**RE: Nusenda Credit Union
6401 Uptown Blvd NE
Grading and Drainage Plans
Engineer's Stamp Date: 1/5/26
Hydrology File: H18D012
Case # HYDR-2026-00001**

Based upon the information provided in your submittal received 01/05/2026, the Grading & Drainage Plan **is not** approved for Building Permit. The following comments need to be addressed for approval of the above referenced project:

GRADING and DRAINAGE PLAN

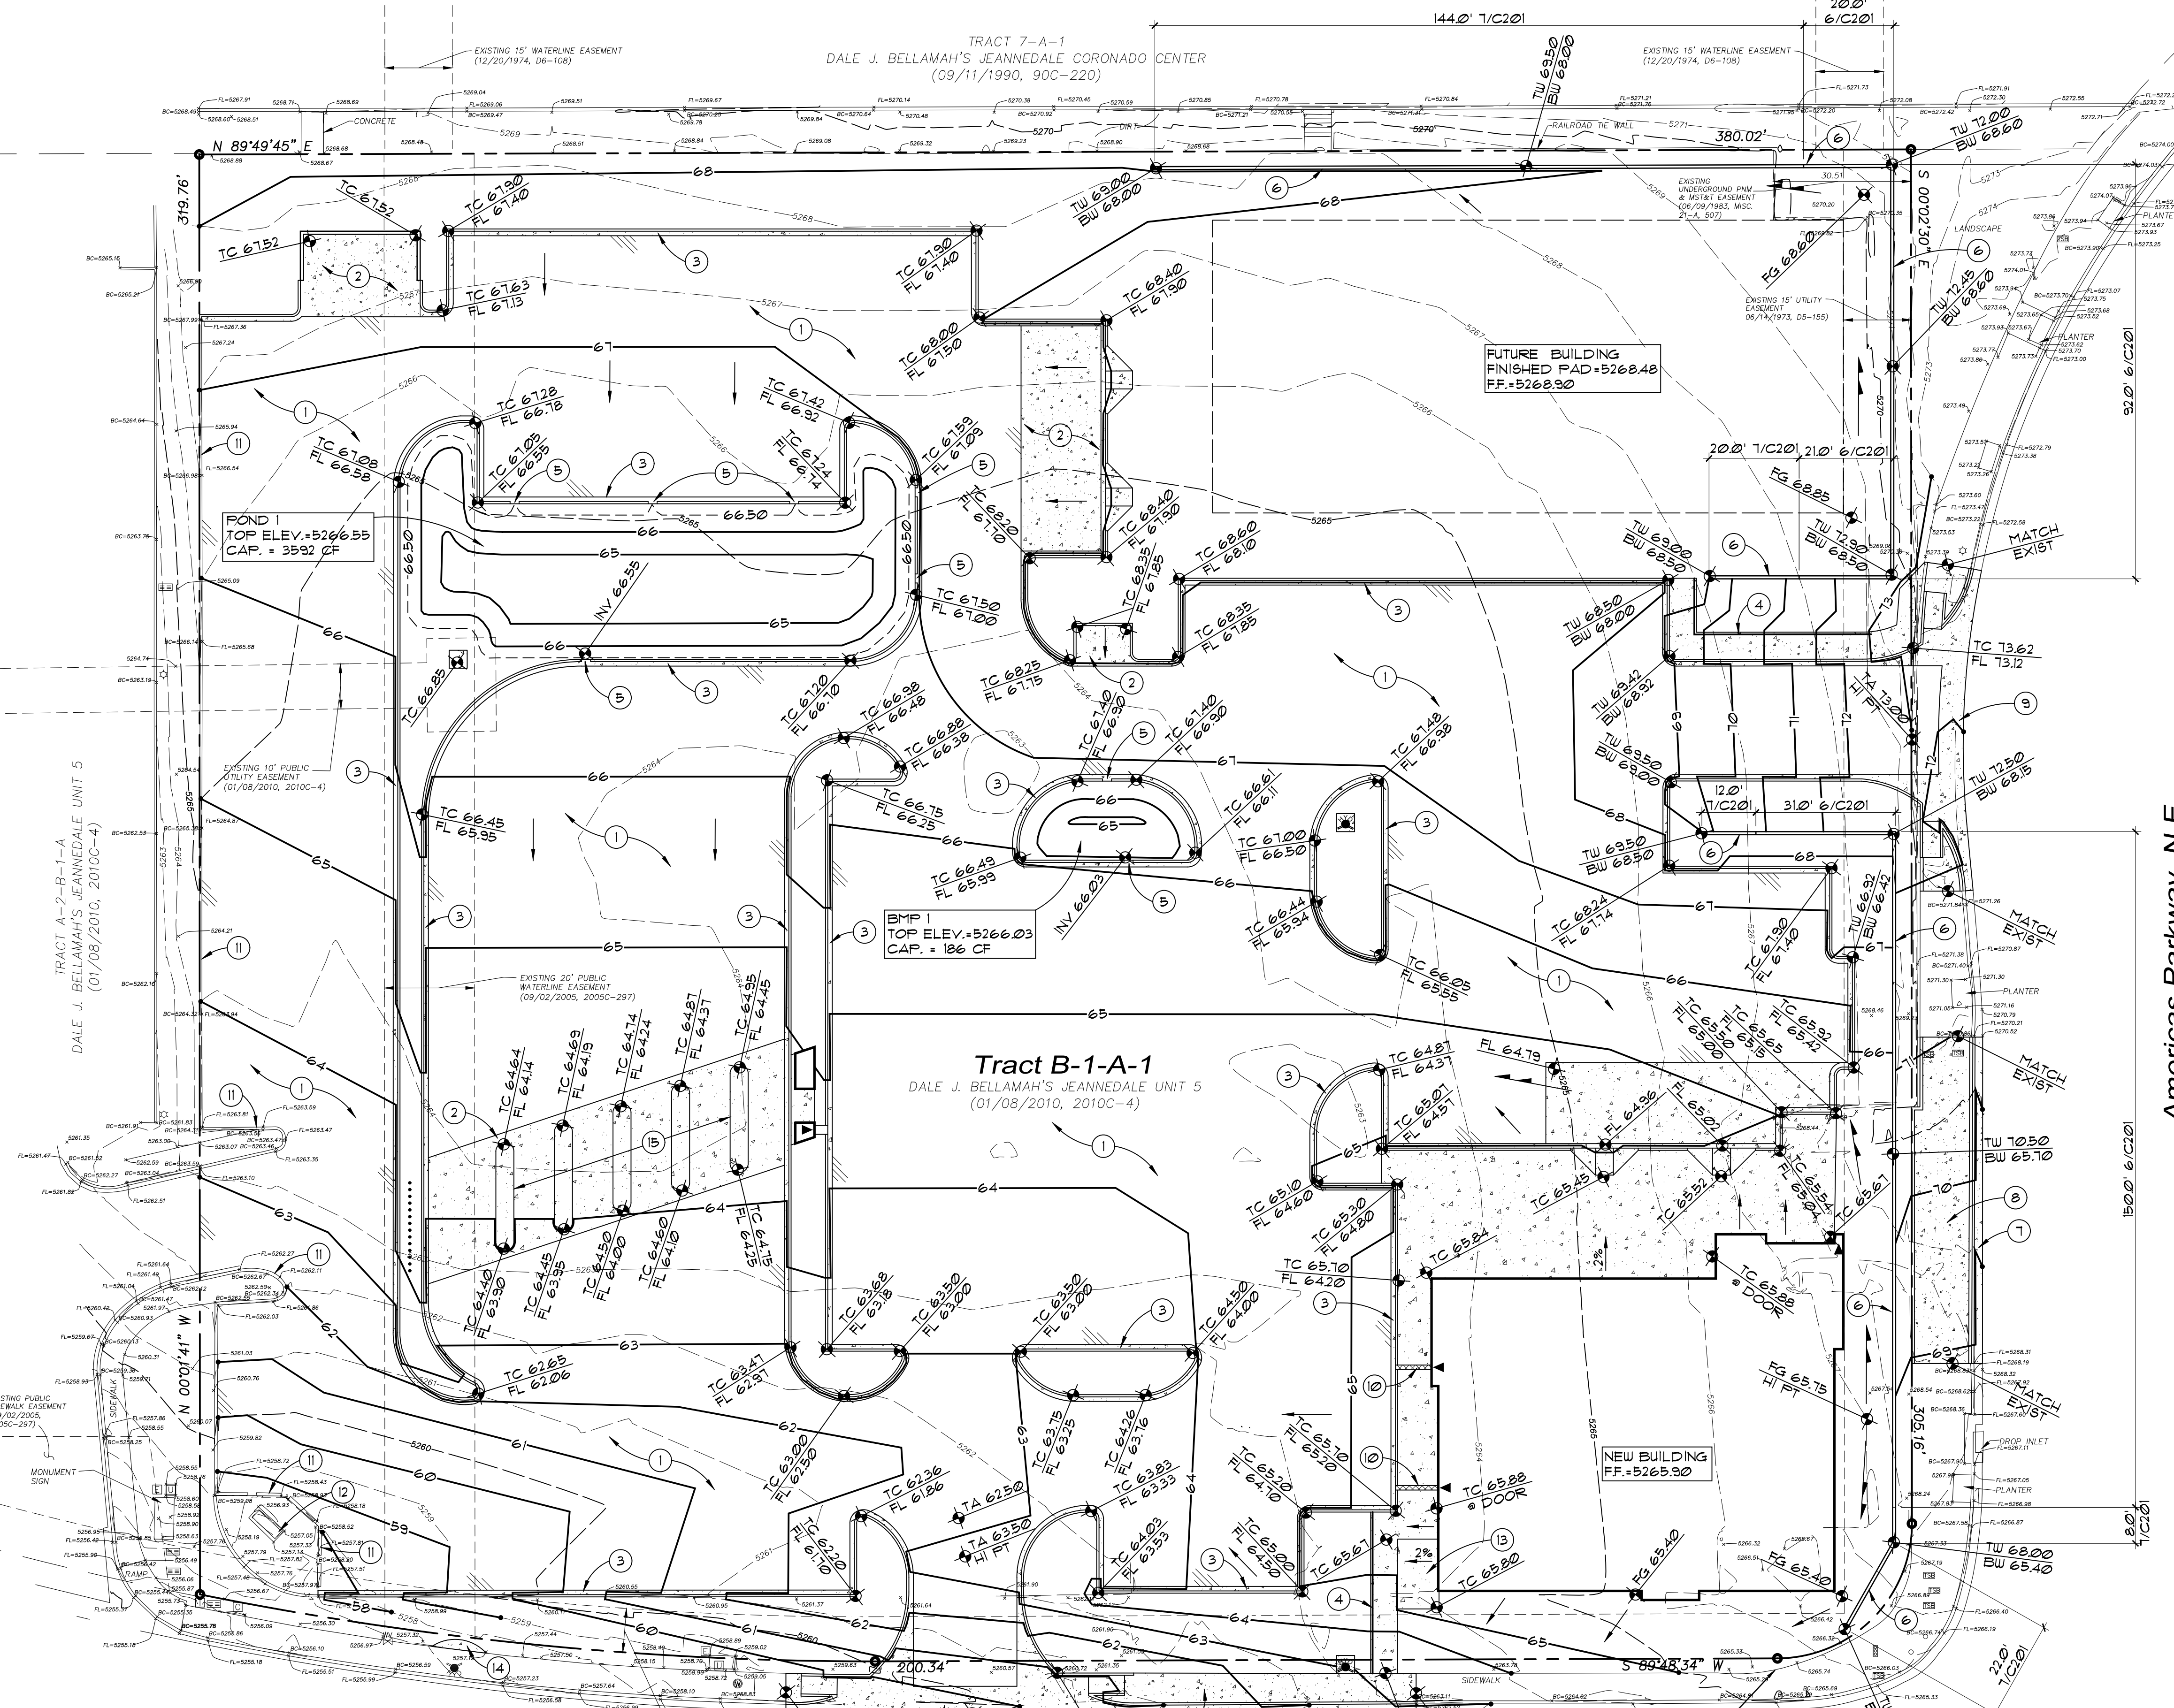
1. Please provide the FIRM Map and floodplain note with effective date.
